Subject: Planning Application Ref: M/151/21/PL - 7 Central Drive - OBJECTION

We are writing to formally express our objection to the above Planning Application for the following reasons:-

sheet 2 of 2

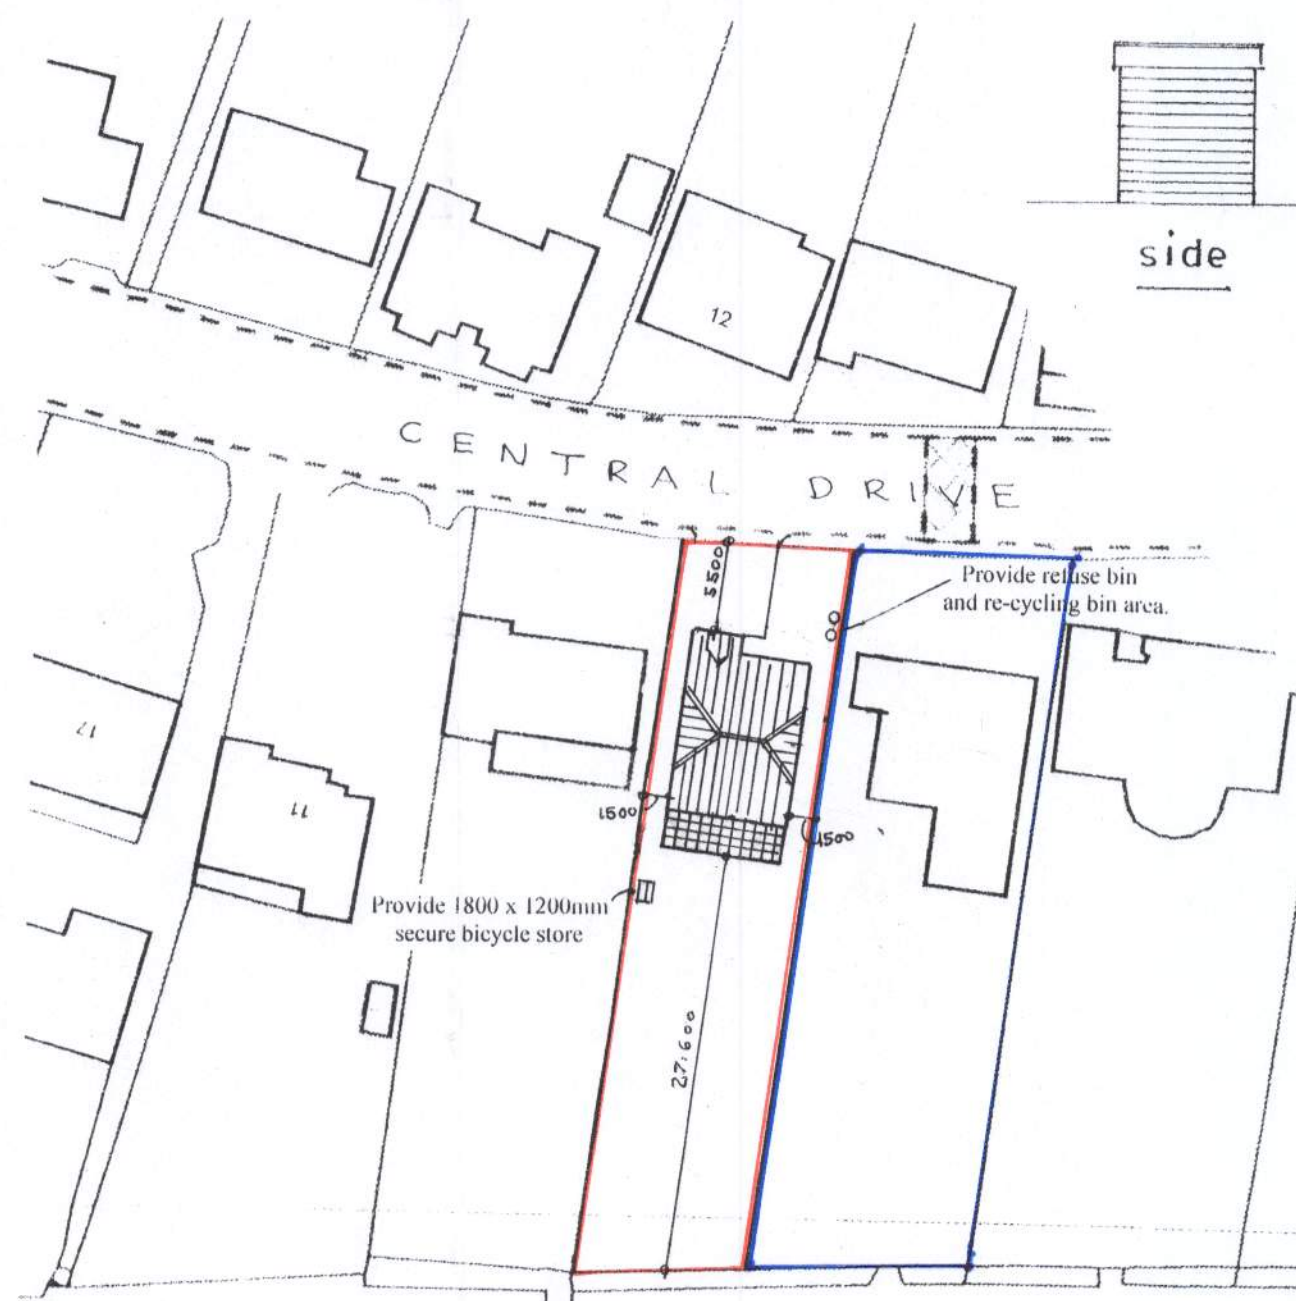
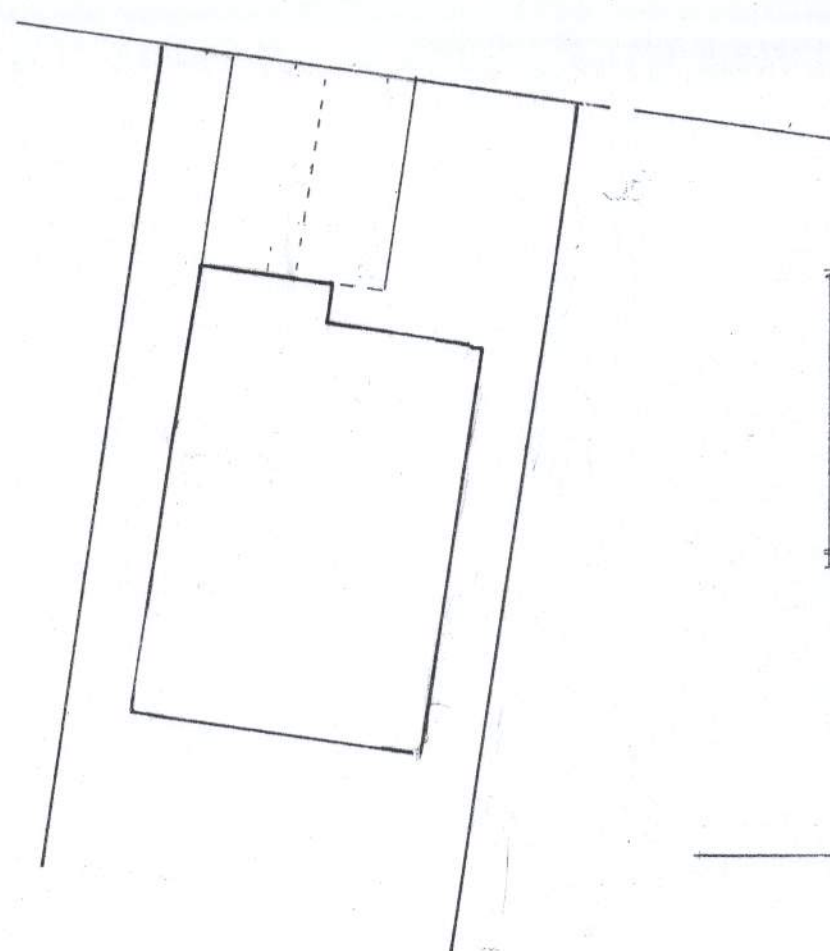
Central Drive narrows towards the east end of the road and some householders at this end of the road have to park on the road because they do not have driveways due to the natural curve of the roadway. In addition, some households, no.7 included, park on the roadway, in addition to their driveway. No 7's driveway spans across the two plots which they own and is already full to capacity with cars. This has a two-fold negative impact; a) the owners are already increasing road hazards by congesting the roadway and b) this will likely worsen if they lose half of their driveway due to it being sold with the plot of land. Additionally, the new owners may decide to park on the road, or have visitors parking on the road, in addition to using their own driveway. This is not only hazardous but will hinder our ability to access our own driveway.

sheet 1a of 2

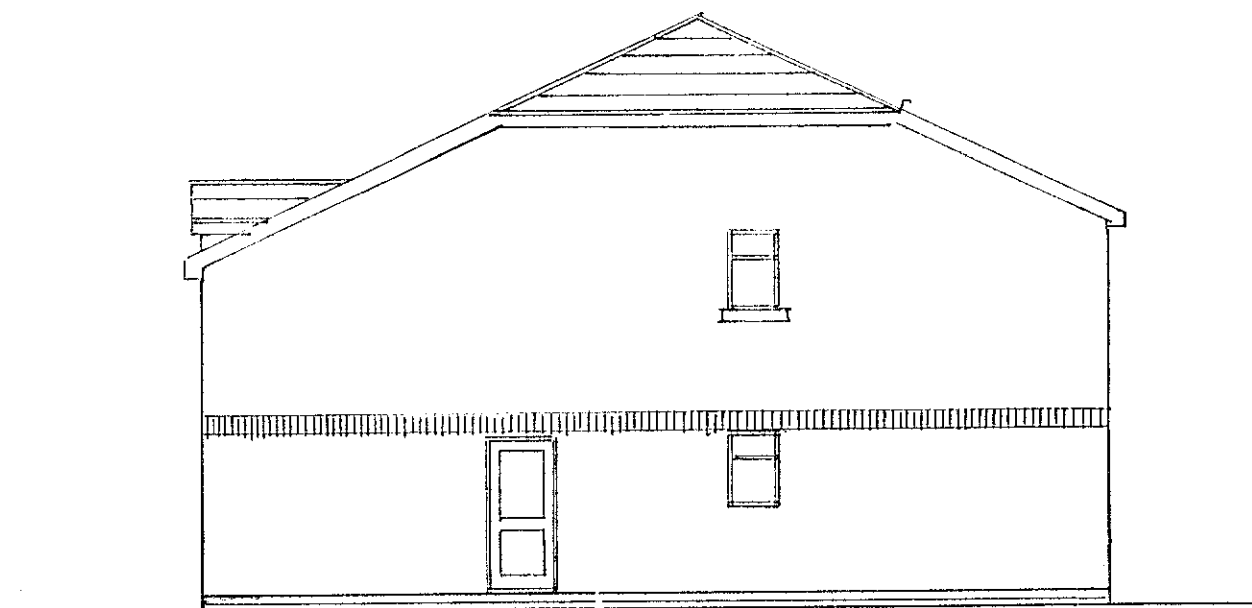
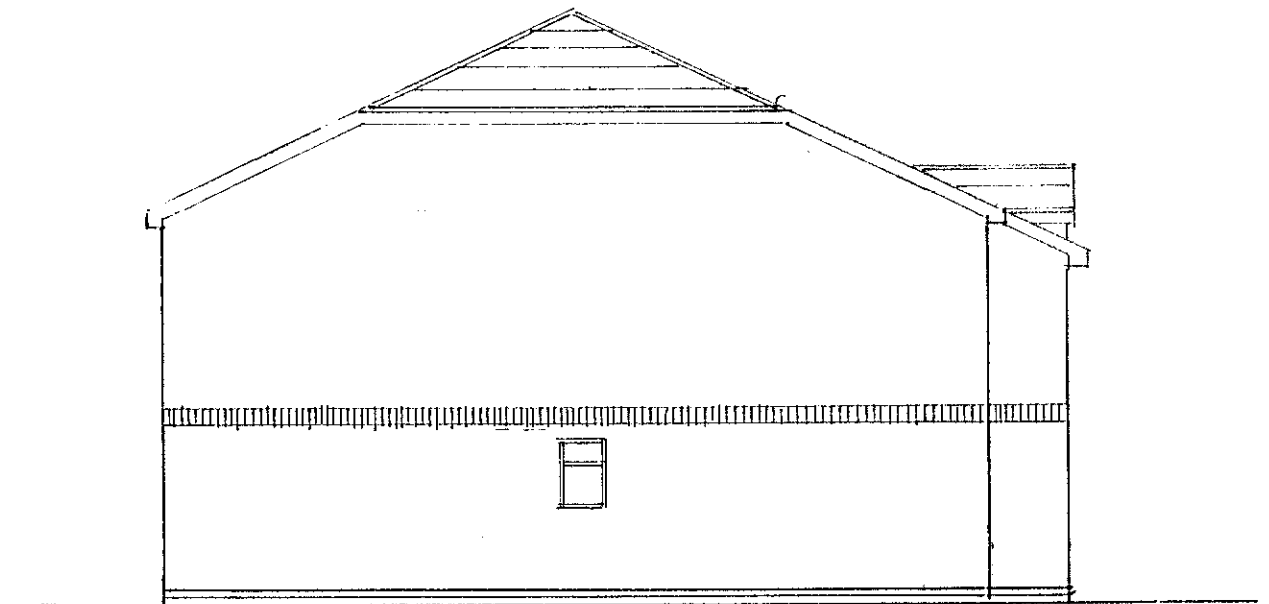
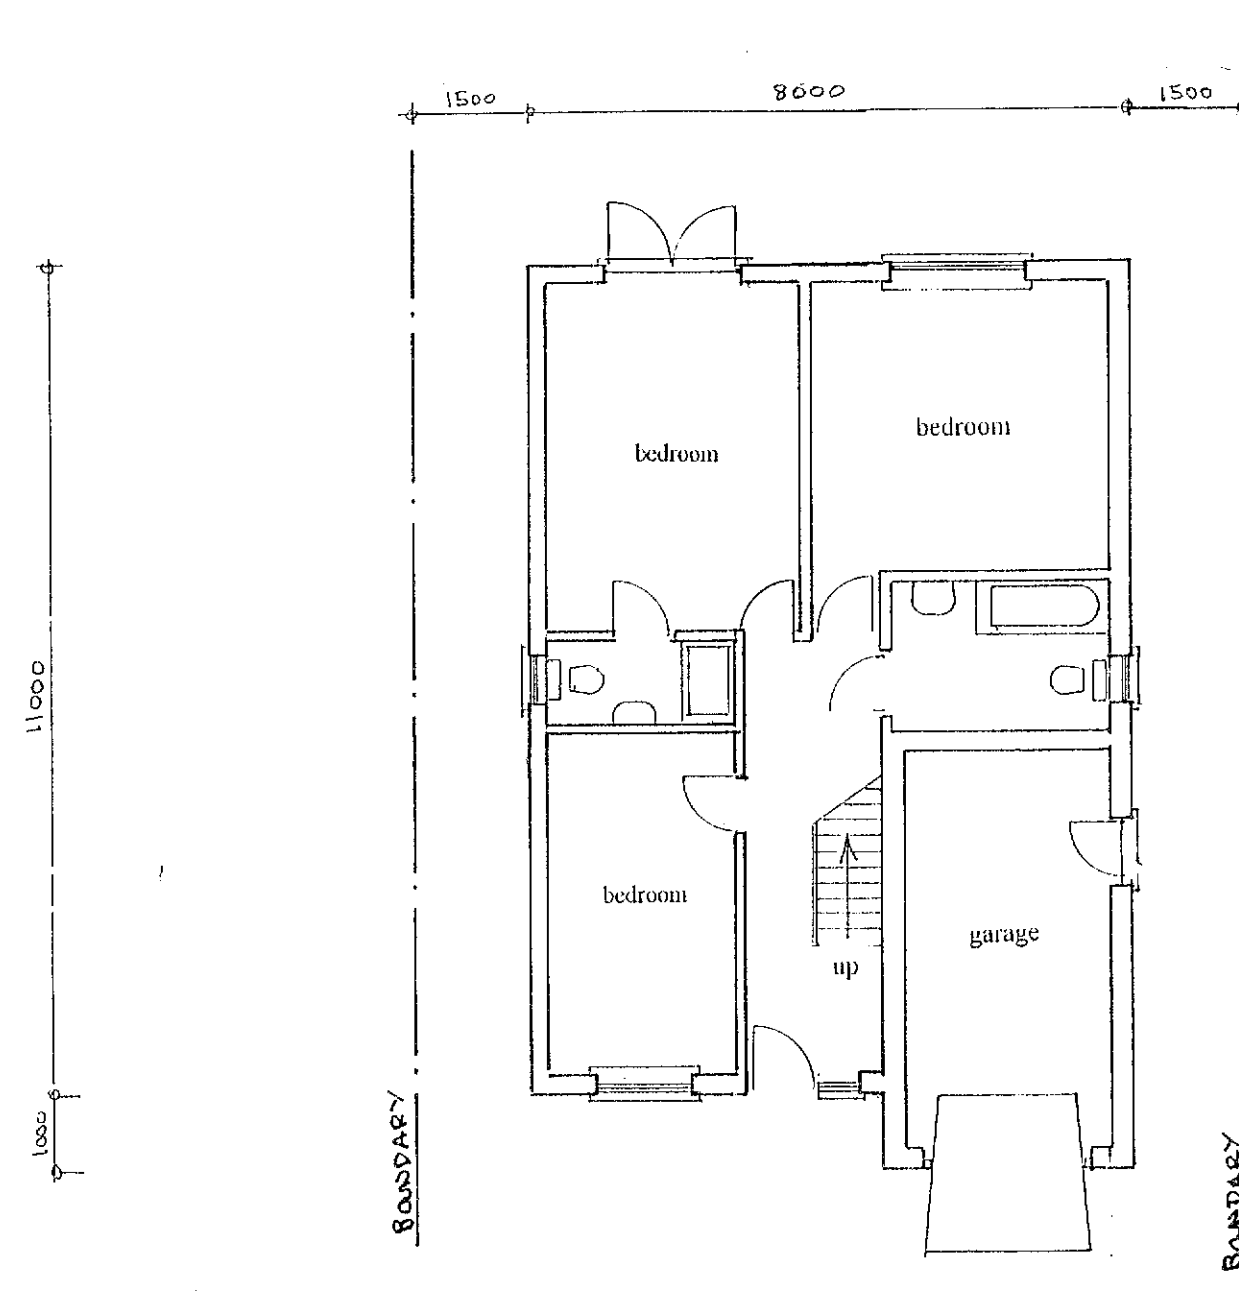
The style of the proposed property is not in keeping with nos 7 and 9 Central Drive and will create a street scene that is detrimental to the surrounding environment. This has already been allowed to happen at no. 5 Central Drive which has caused a great deal of upset to neighbours in the immediate vicinity and we would not wish this to set a precedent for no. 7.
